**Michael Clynch Associates  
Architect & Town Planner  
14 Huddersfield Road  
Ingbirchworth  
S36 7GF**

10 November 2013

**2013/1169**

I refer to your letter of 5 November. I understand your system has not printed all the drawings so you need to see the full submission.

..... 1:500 SITE LAYOUT DRG S1 10/2013

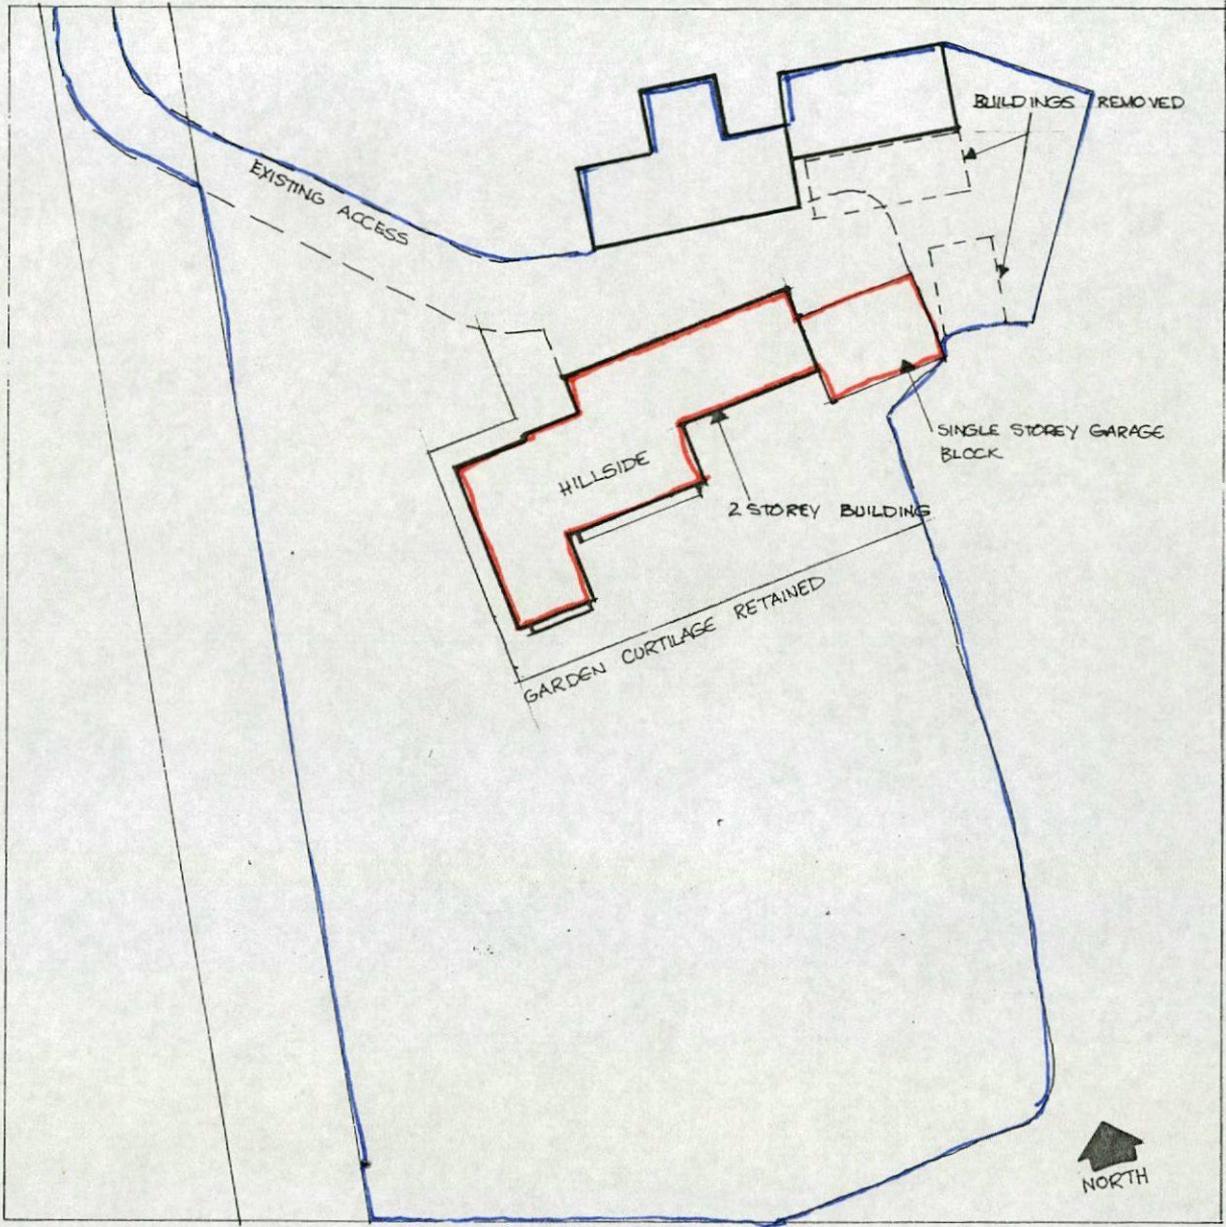
I have marked up the site plan (S1) to help clarify which is new, which is demolished and which exists. I hope this is helpful.
